Application No: BE/59/21/PL
Site Address: 339 Chichester Road Bersted PO21 5AN
Description of works: Replacement of blockwork boundary wall with fence and new vehicular access (resubmission of BE/149/21/PL).

Thank you for your internet representation made on 2nd June 2021 which has been recorded as an objection with the comments as follows:

SITE PLAN - SHOWING VISIBILITY SPLAYS
1:500 SCALE (at A3)

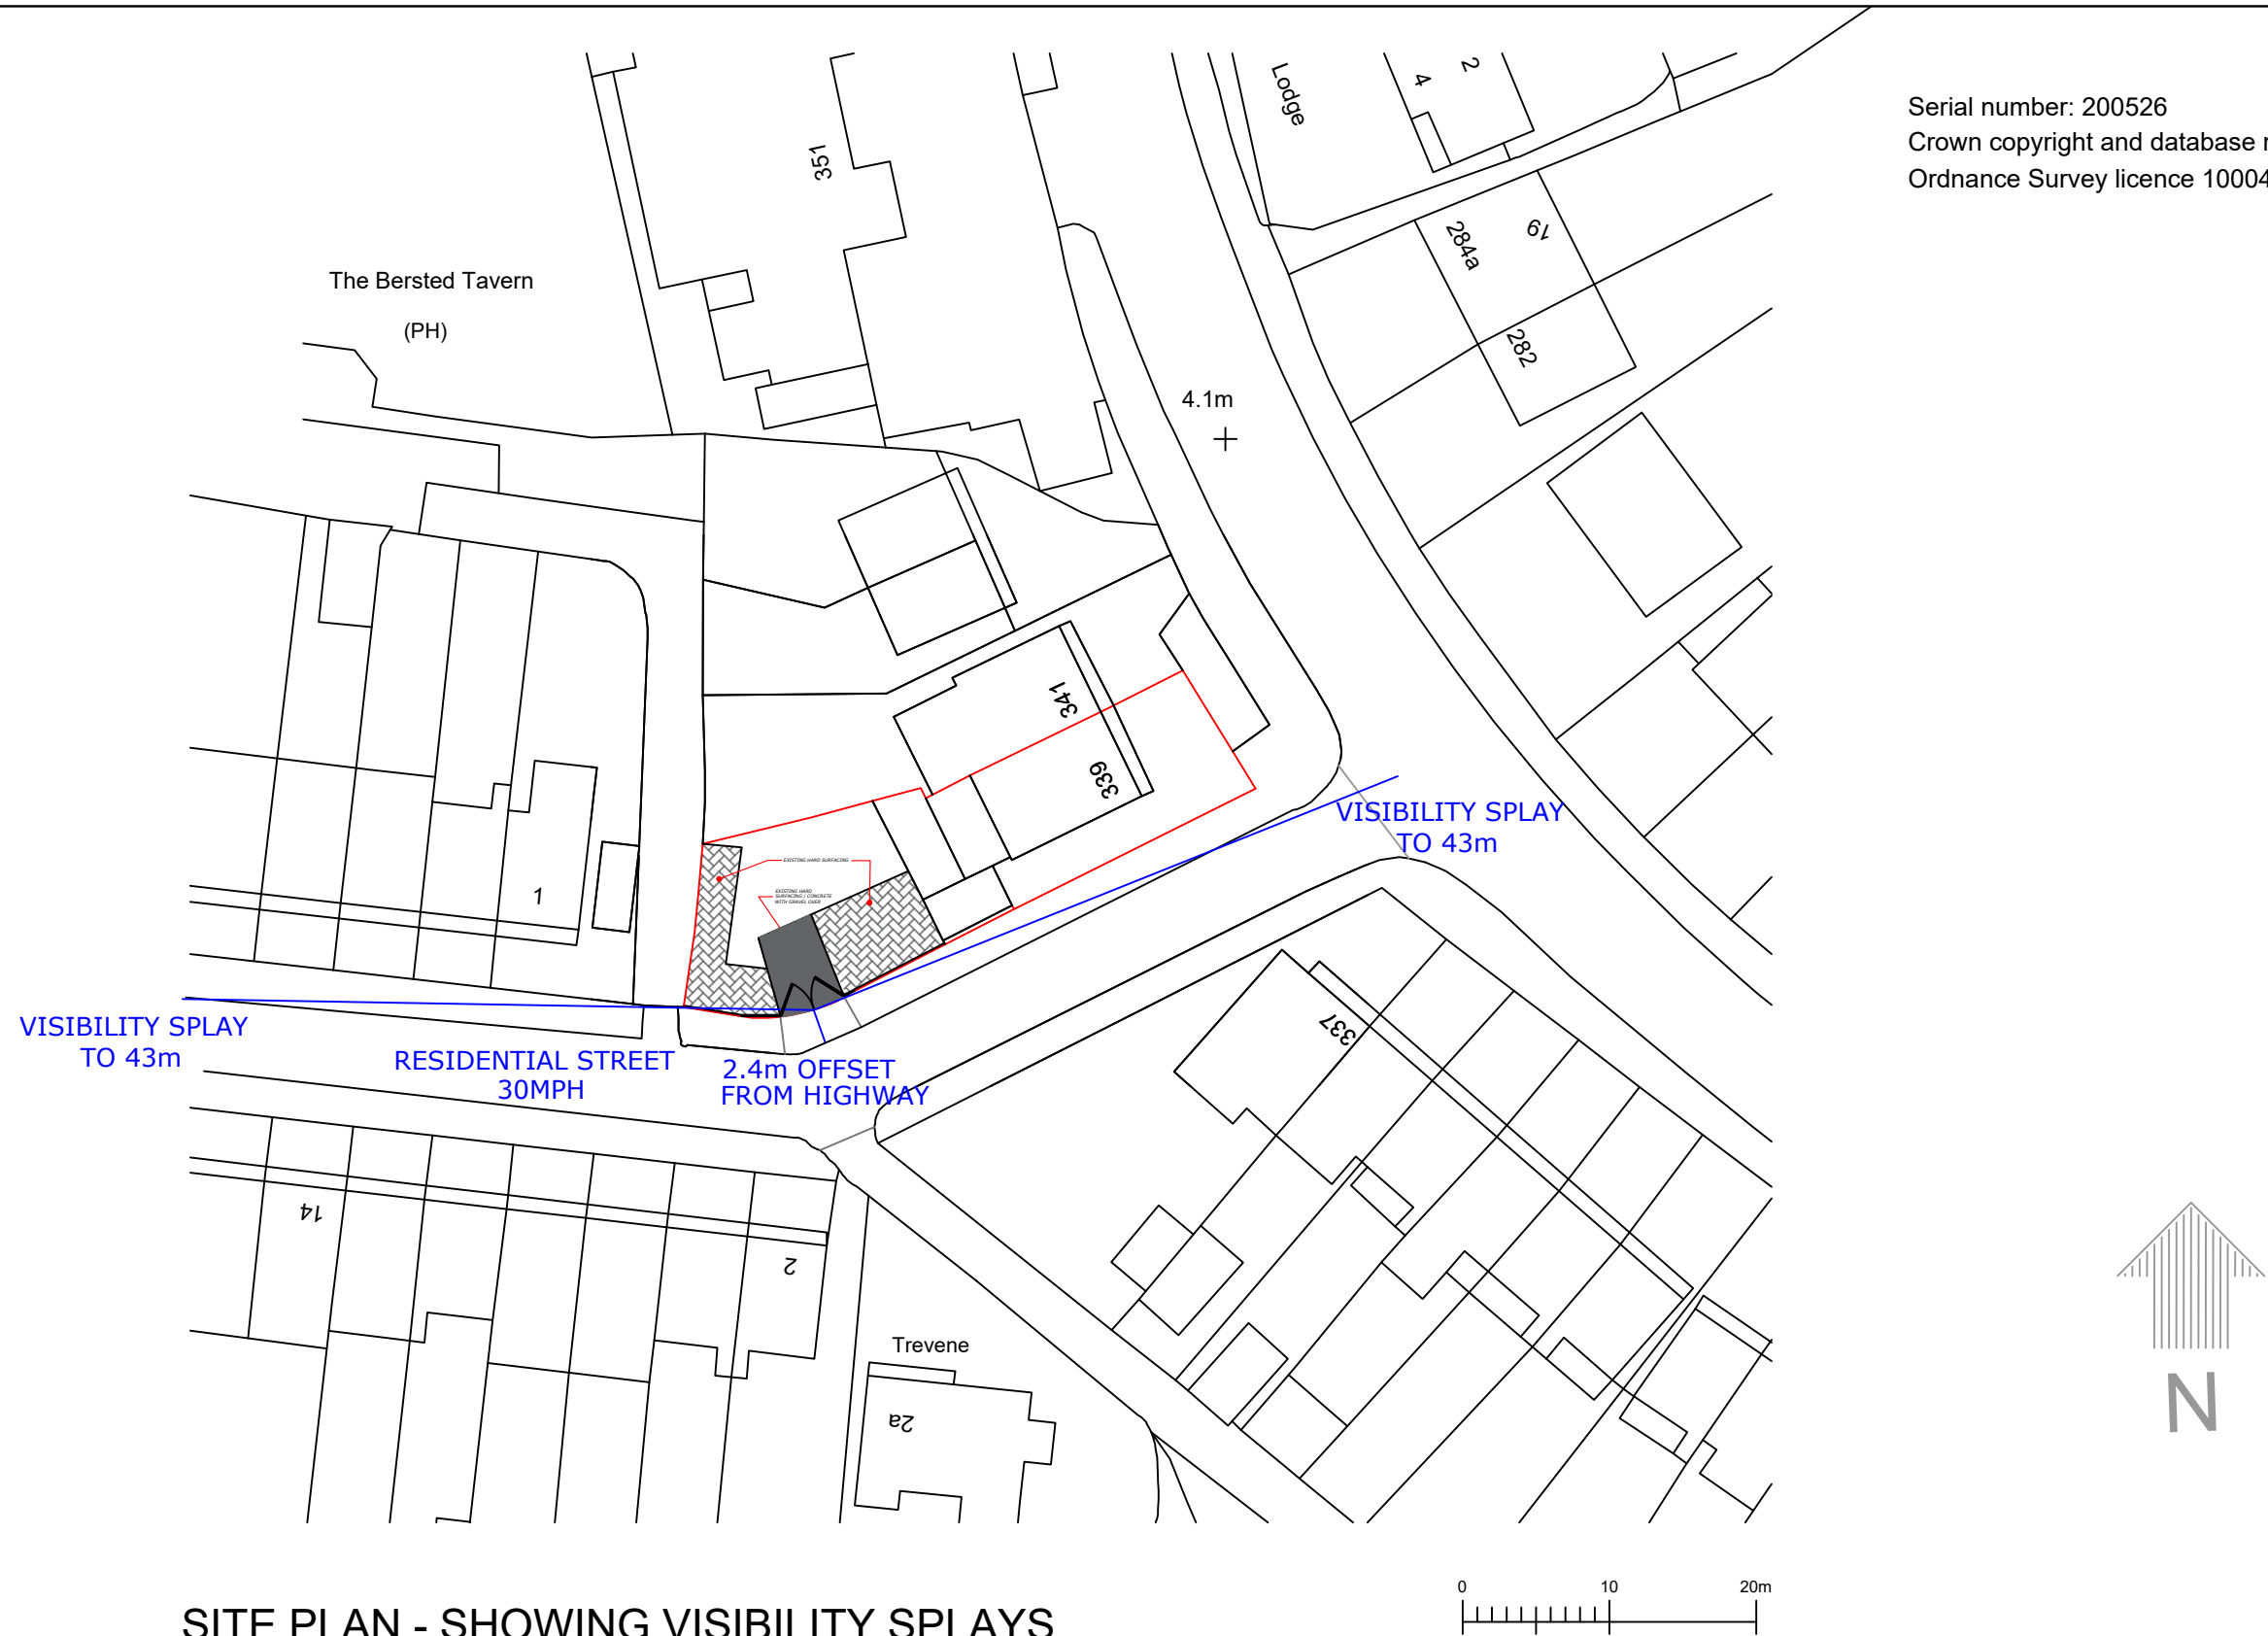
In response to the WSCC Highways Consultation the provision for 4 parking spaces are not included in the plans. The Planning Application is for 1 space at the rear of the property so either Kyran Schneider has misread the Planning Application and for what Mr Delaney is applying.

Again as previously pointed out, the drawings do not show visibility splays just the required distance and the Vehicular Access is in the wrong position on the drawings. If someone came out and surveyed the site it would become clear that Mr Delaney and his agent are manipulating the drawings within the application to suit their application. The fact no one has visited from WSCC Highways and haven't surveyed the site properly they are relying on plans that are inaccurate as proven at the Parish Council meeting on 1st June 2021.
